From: Jonathan Best <Jonathan.Best@arun.gov.uk>
Sent: 18 June 2025 16:00
To: Planning.Responses <Planning.Responses@arun.gov.uk>
Cc: Kathryn Welch <Kathryn.Welch@arun.gov.uk>
Subject: LU/93/25/PL

Units 5-7, Watersmead Business Park Norway Lane/Worthing Road Littlehampton BN17 6LS.

I have reviewed this application with regards to ecology and Biodiversity Net Gain.

Recommendation: No objection subject to conditions.

number **FIGURE 1** rev  
**A**

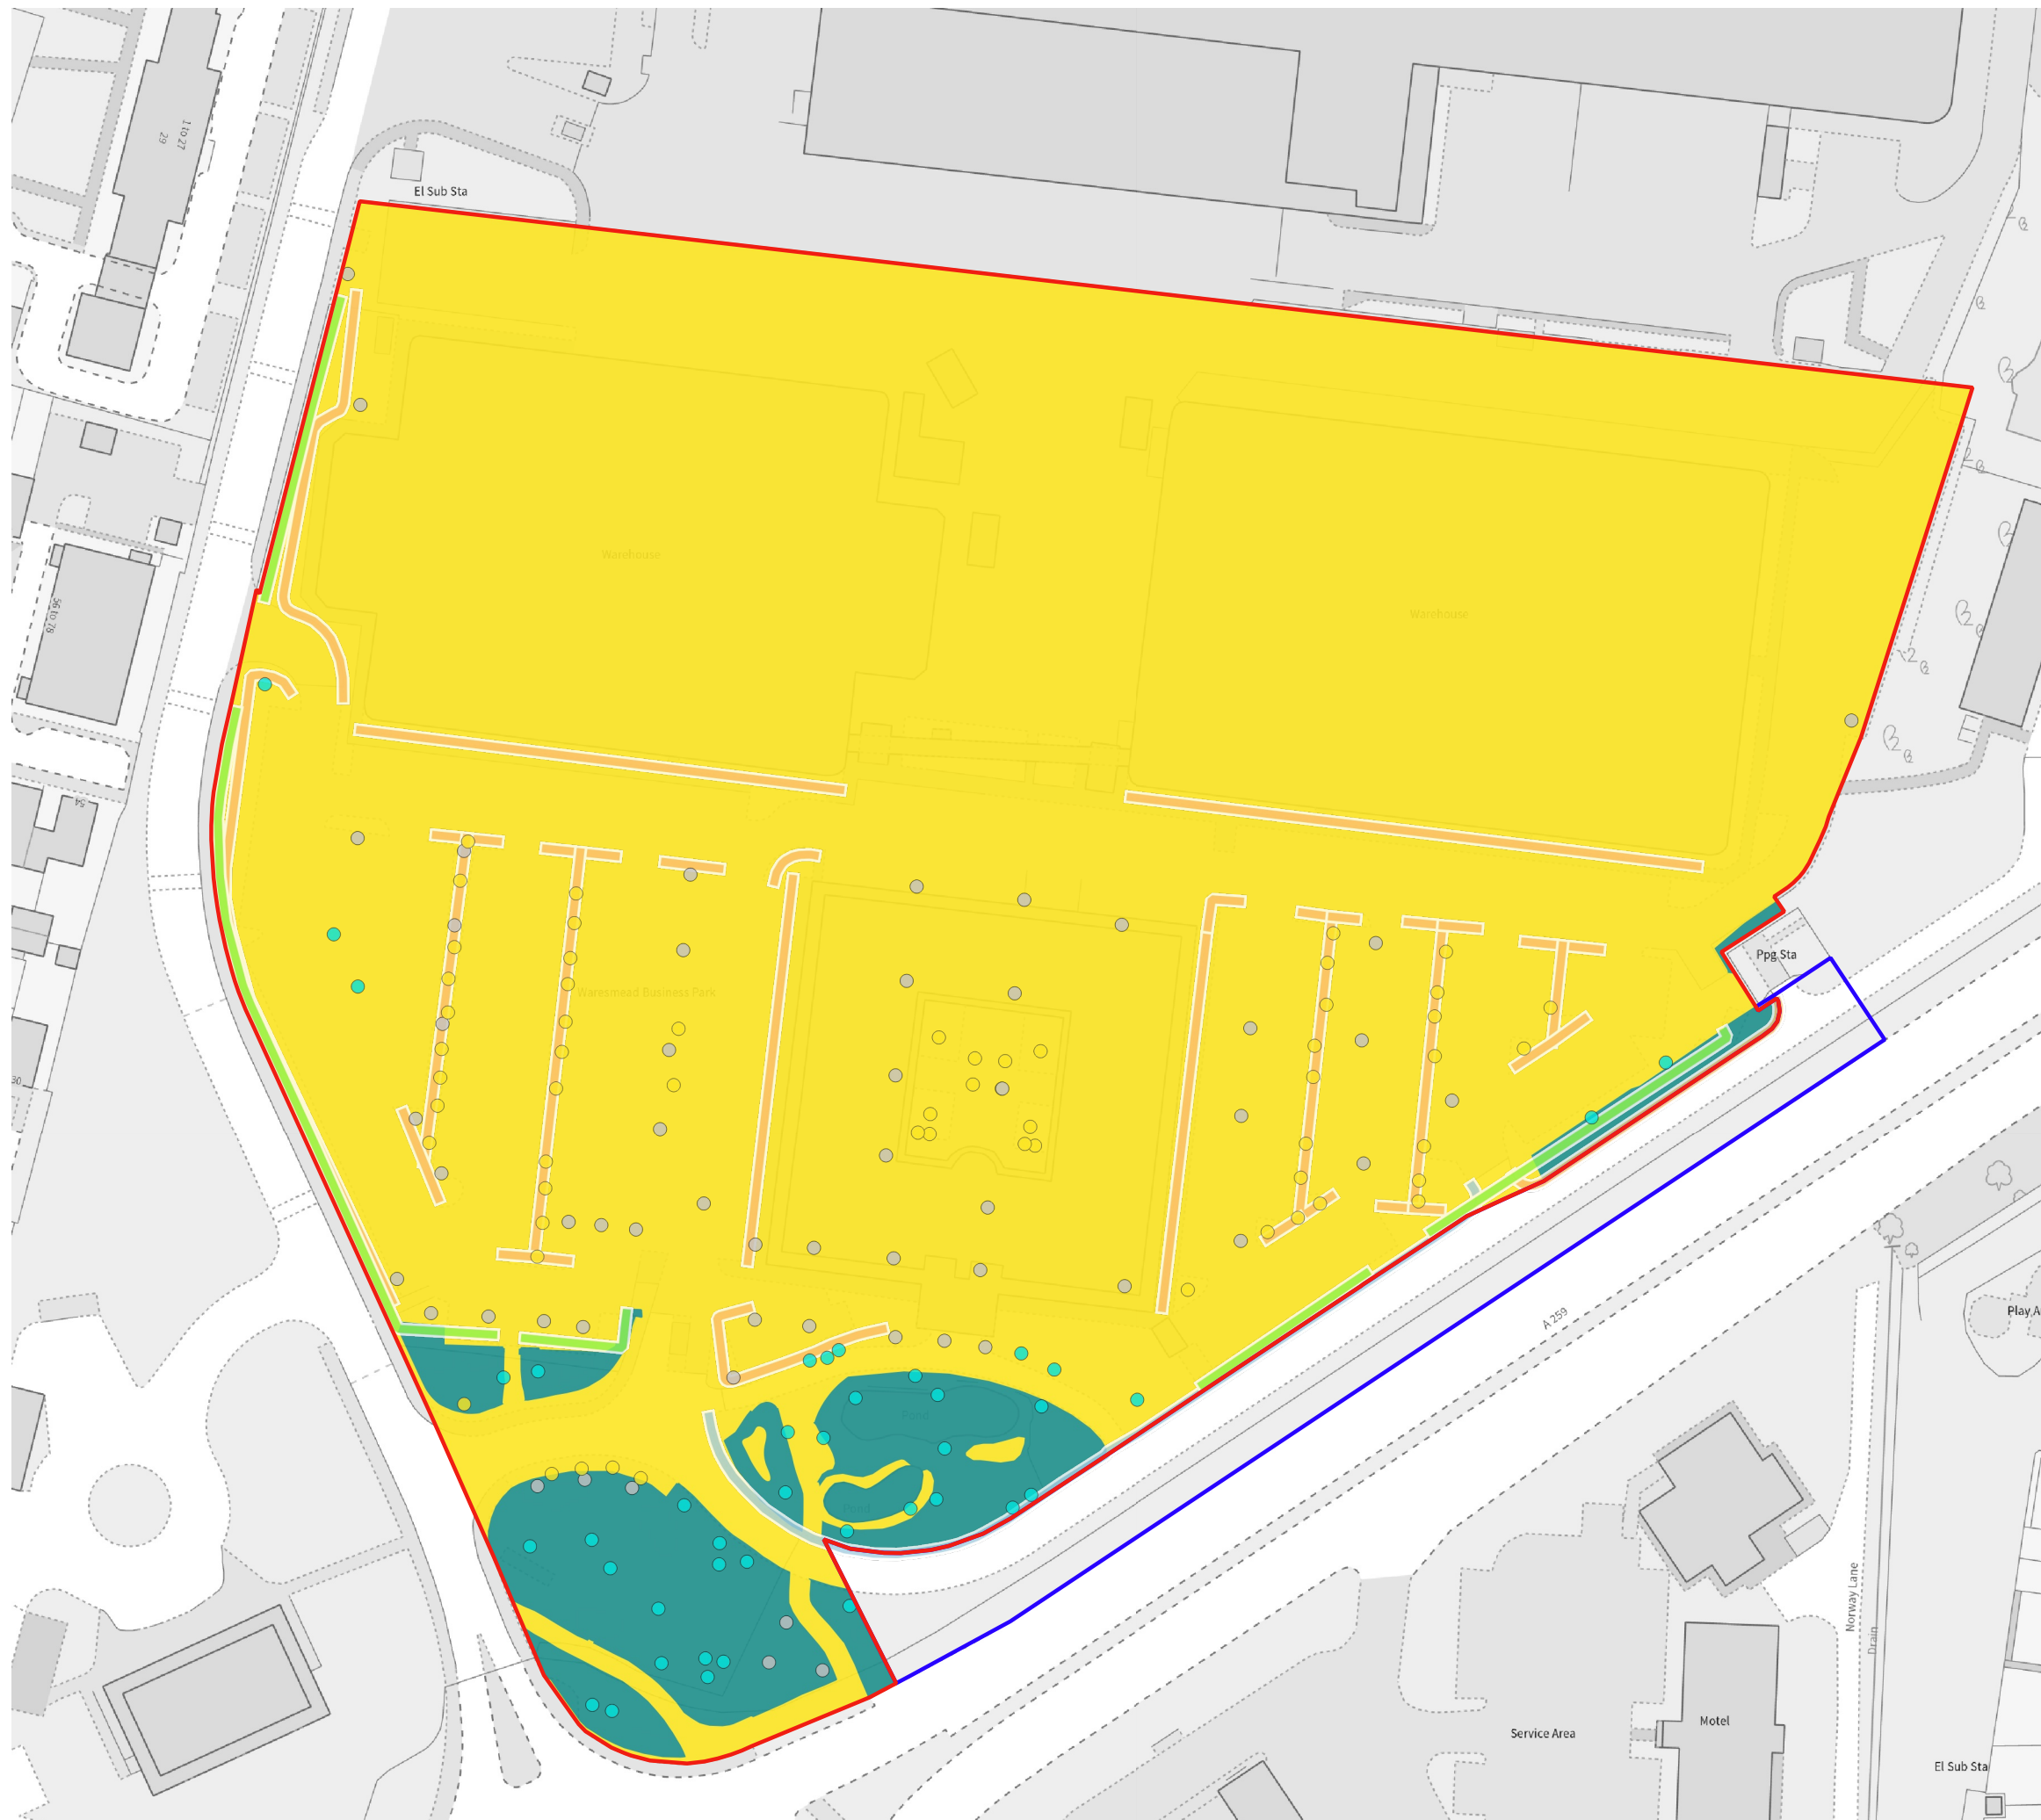
The BNG report and Statutory Metric shows a loss of 2.14 habitat units which equals 24.60%. Offsite provision of BNG units is required

There is a calculated net gain of 1.18 BU for hedgerow units, equivalent to 115.03%, associated with the current development proposals.

The Ecological Assessment makes recommendations for ecological enhancements. Including Bat and Bird boxes, native planting (including 0.161KM of species rich native hedgerow with trees identifies in the BNG report) and a bat sensitive lighting scheme.

The species rich native hedgerow and trees are listed as high distinctiveness habitat in the submitted metric. This habitat is considered significant and should be secured by a S106 agreement.

BNG1,

PCBNGMON1

ECOBNG2 – to include details of bat and bird boxes and native planting.
